DE-2025/82/D

SUBMISSION TO EXHIBITED DOCUMENTS

Development	Smith Street Modification 4 - Alterations and Additions (SSD-67895459-Mod-4) - Request to provide advice on the Modification Application and Report
Location	Lot 201 DP 1313965 120 Street WOLLONGONG NSW 2500

1 NORTH ELEVATION (CHARLOTTE STREET)
Scale: 1 : 200

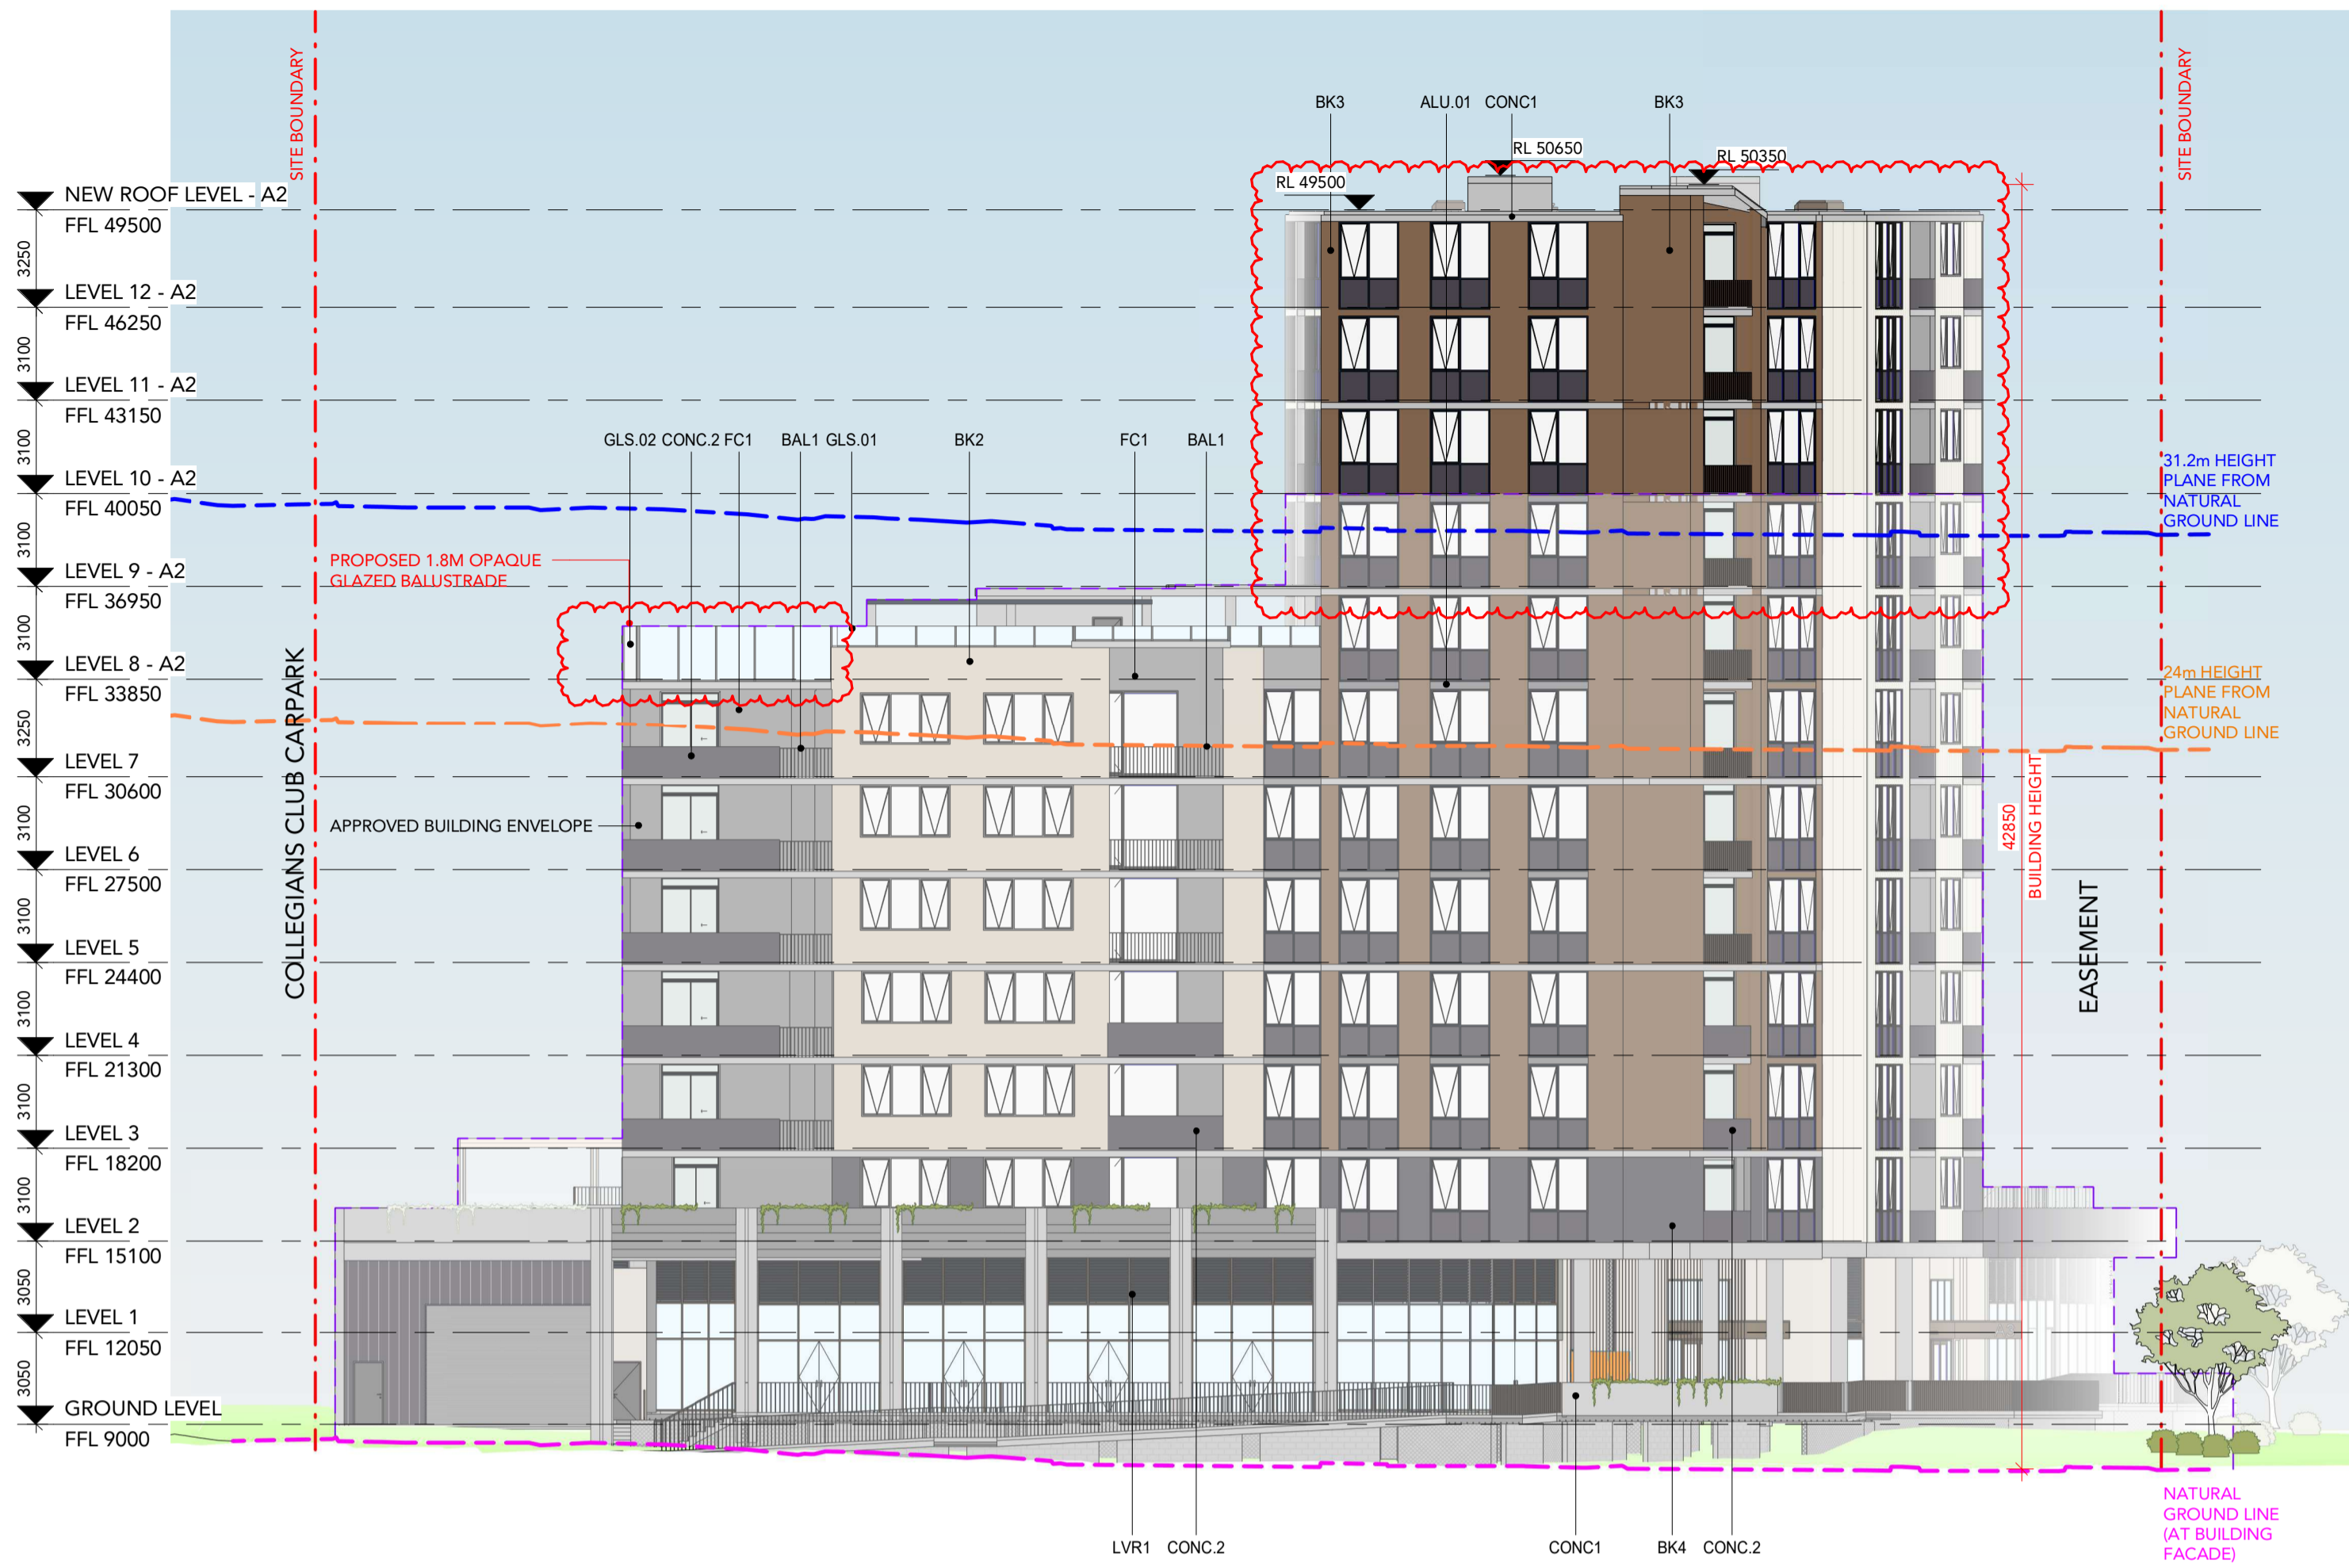
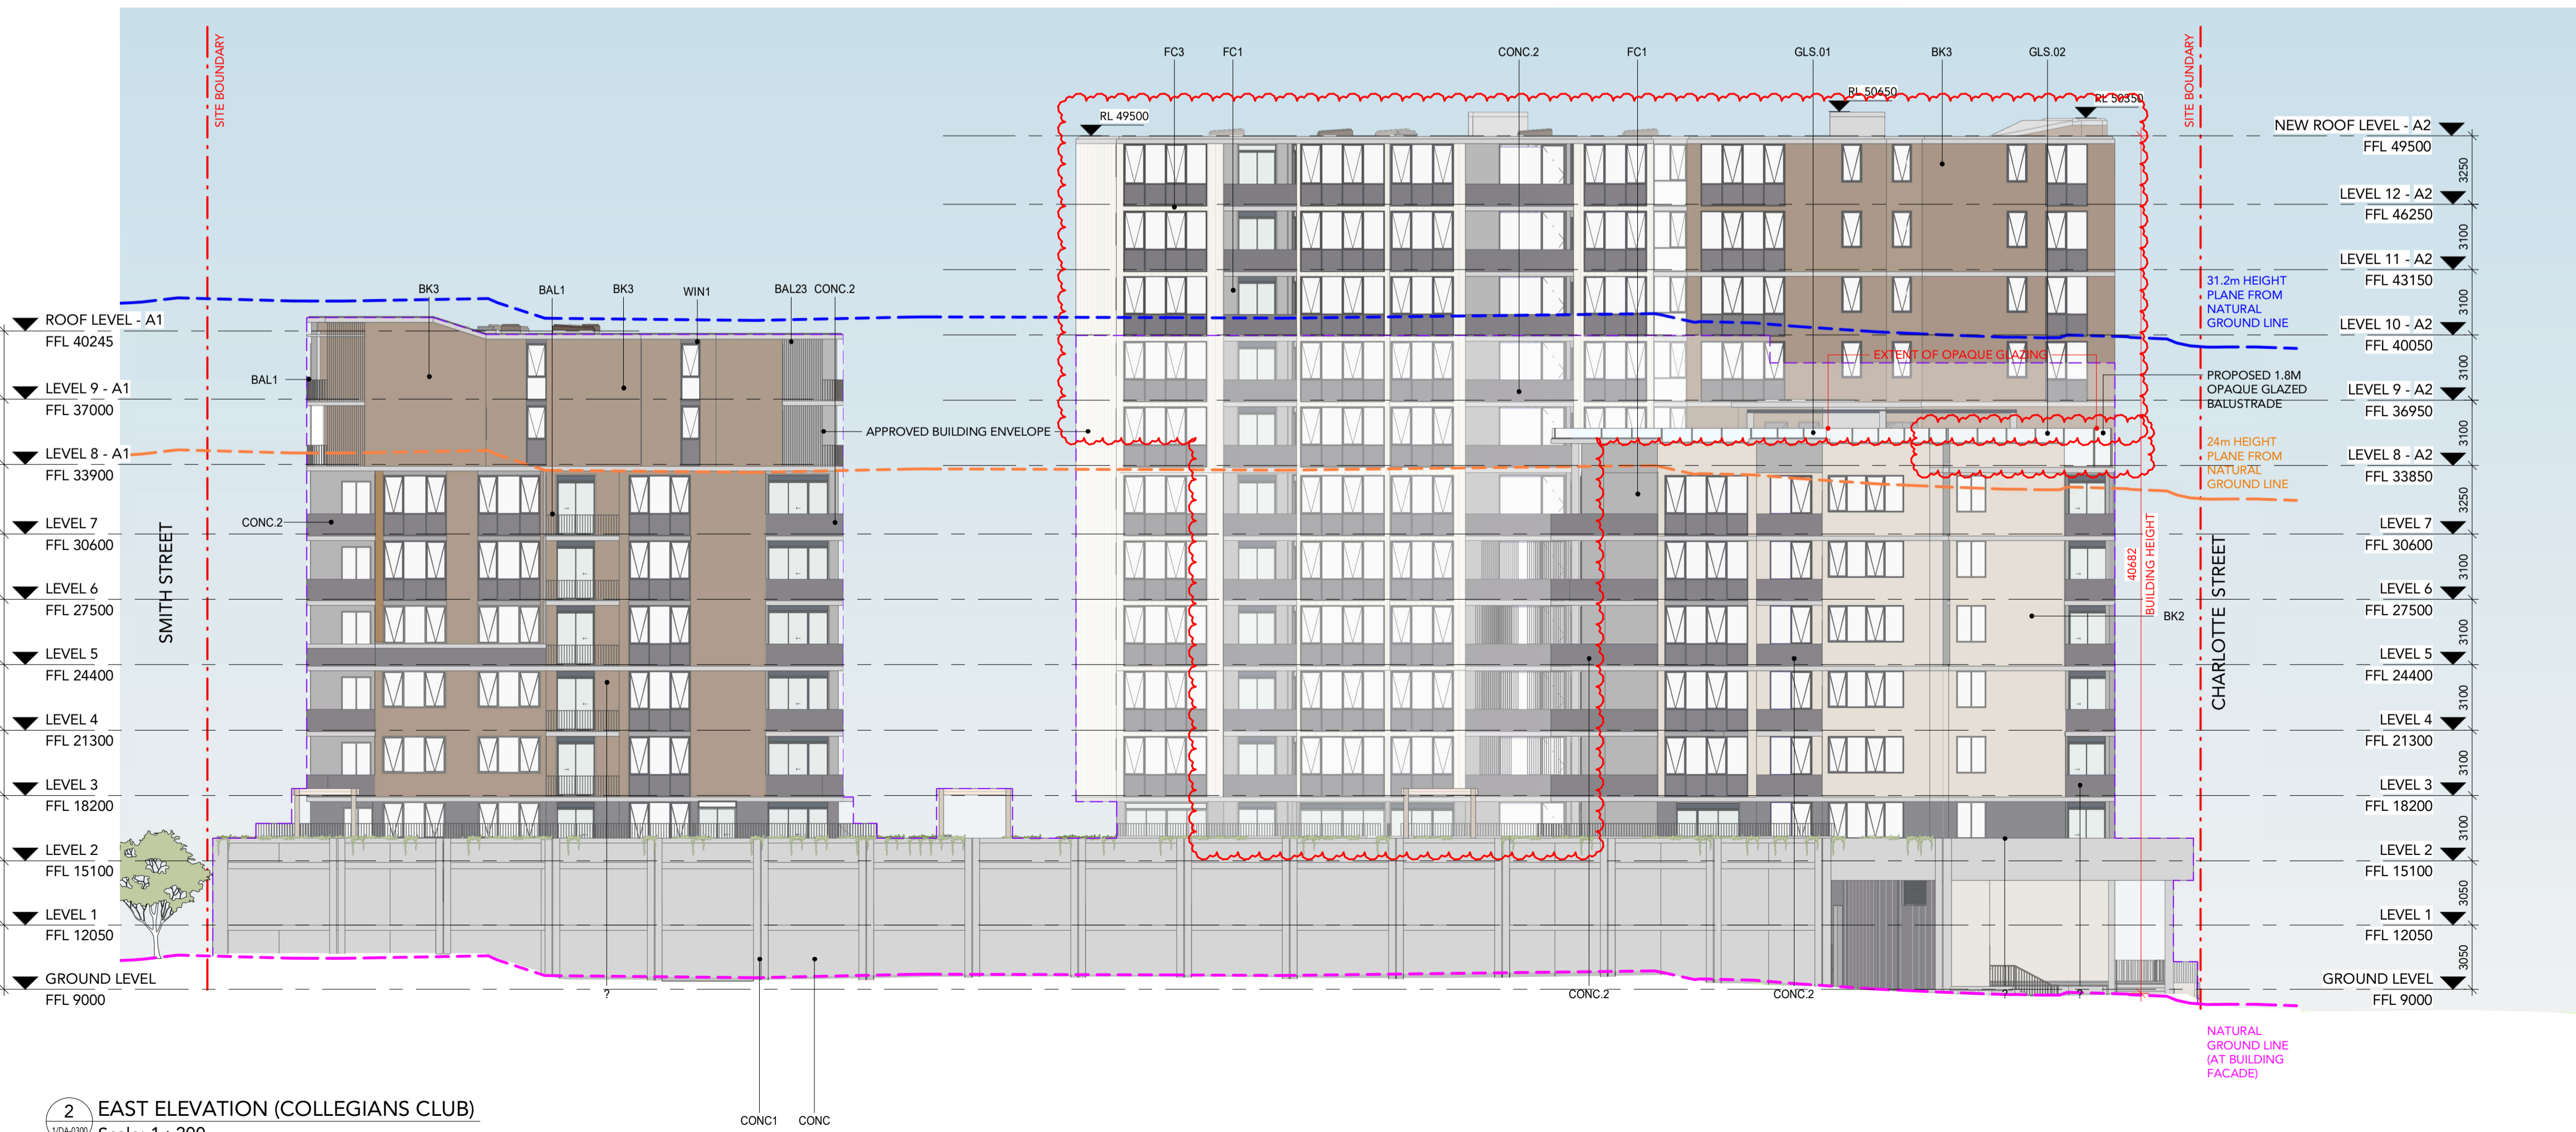
3. The proposed modification would result in Building 2 having a building height of 41.655m. This exceeds the maximum 24m height permitted in Wollongong Local Environmental Plan 2009 and 24m in Council’s exhibited Draft Flinders Street Urban Design Framework (Draft UDF). It also exceeds the maximum 30% affordable housing height bonus provided under State Environmental Planning Policy (Housing) 2021, which limits height to 31.2m.
4. Council does not consider the applicant has adequately justified contravening the permitted height standards. The justification on pages 33 and 35 of the Colliers report does not demonstrate that

compliance with the height standard is unreasonable or unnecessary in the circumstances, nor does it establish adequate planning grounds for the height exceedance. Specifically, Council notes that the proposed height is inconsistent with the Draft UDF, despite the applicant's claims of compliance.

5. If the Department supports additional height beyond that foreshadowed in the Draft UDF and permitted by WLEP 2009 and SEPP (Housing) 2021, it may be more appropriate to provide additional uplift to the southern tower facing Smith Street in order to ensure it sits outside of the view corridor. If any uplift remains proposed to the northern tower, it should be focused on the southern portion of this tower only around Lift A3, which would consist of approximately 4-5 units per floor only.
